January 26, 2022

**Re: 3-Bay Oil Change
5400 Menaul Blvd NE
Traffic Circulation Layout**
Engineer's Stamp 01-20-2022 (H18-D074)

Based upon the information provided in your submittal, for RE-APPROVAL, received 01-21-2022, the above referenced plan cannot be approved for Building Permit until the following comments are addressed:

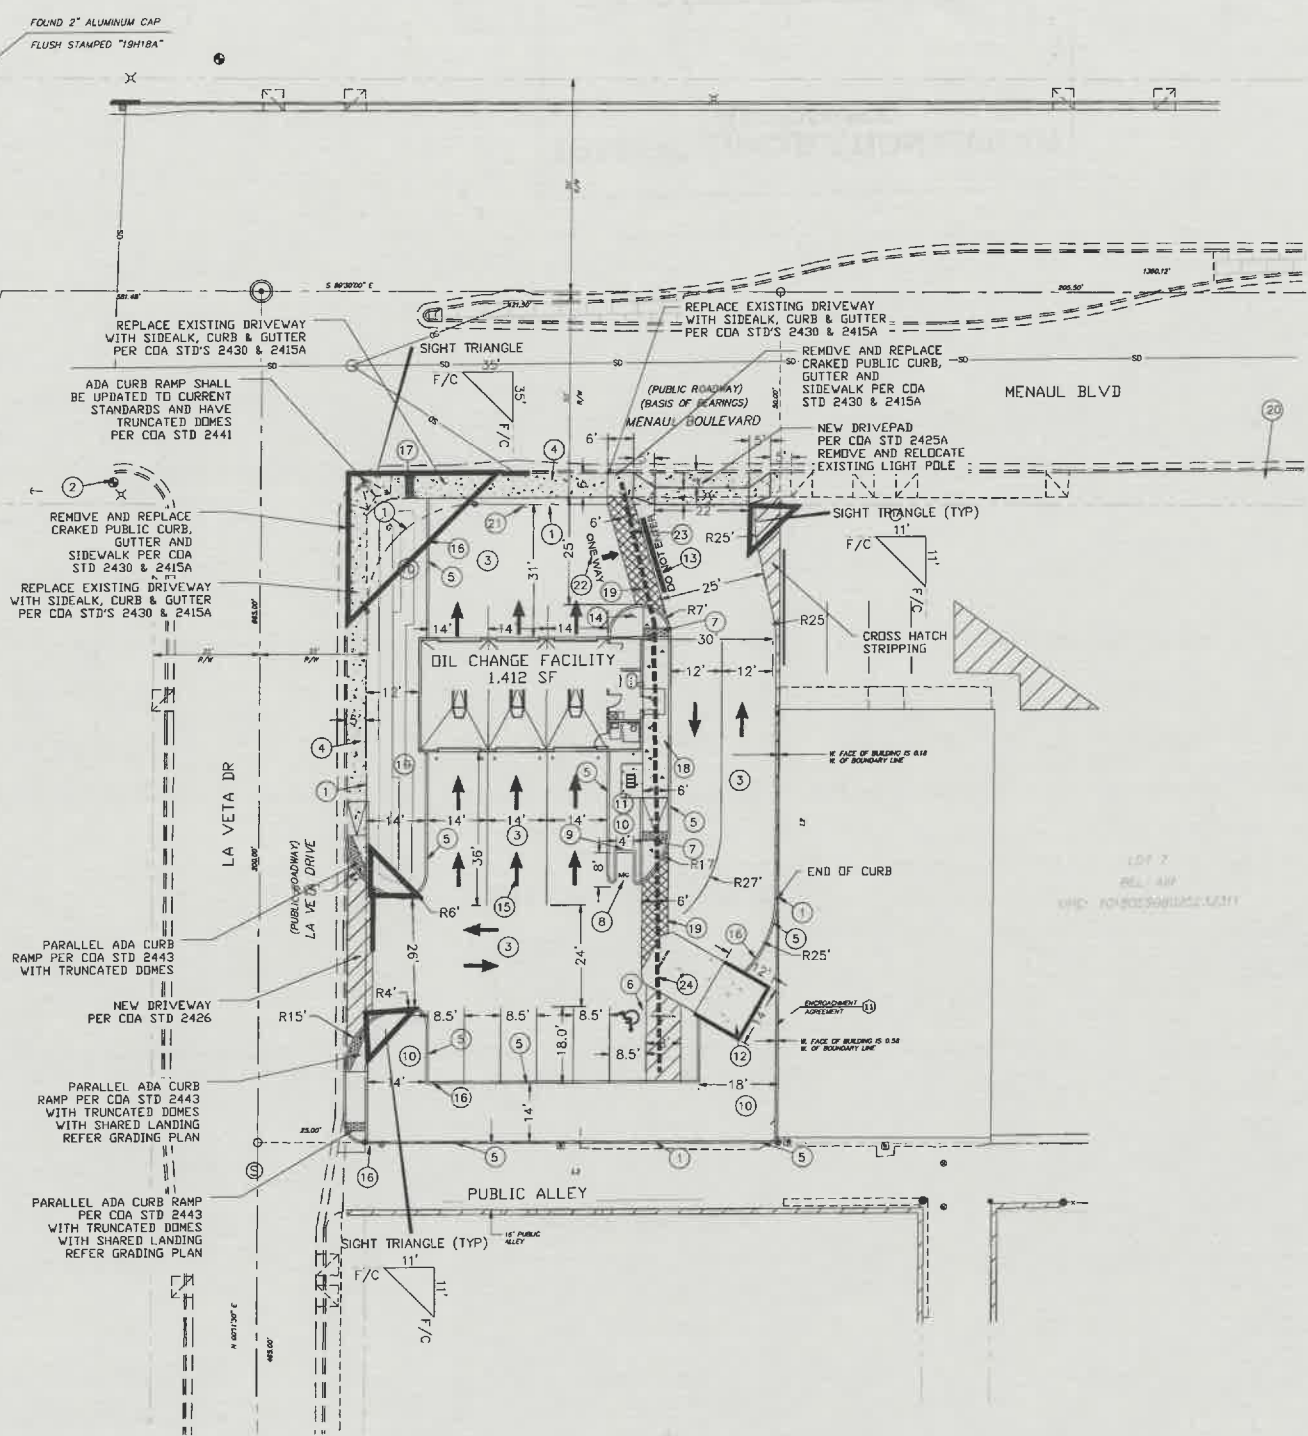
1. Provide approved Plat demonstrating adjused lot lines. AGIS shows lots lines in a different location.
2. The new proposed 6 ft ADA pedestrian pathway from Menaul appears to be a bit close to the propose driveway transition. Please verify there is not conflict between pathway and driveway transition/ramp.
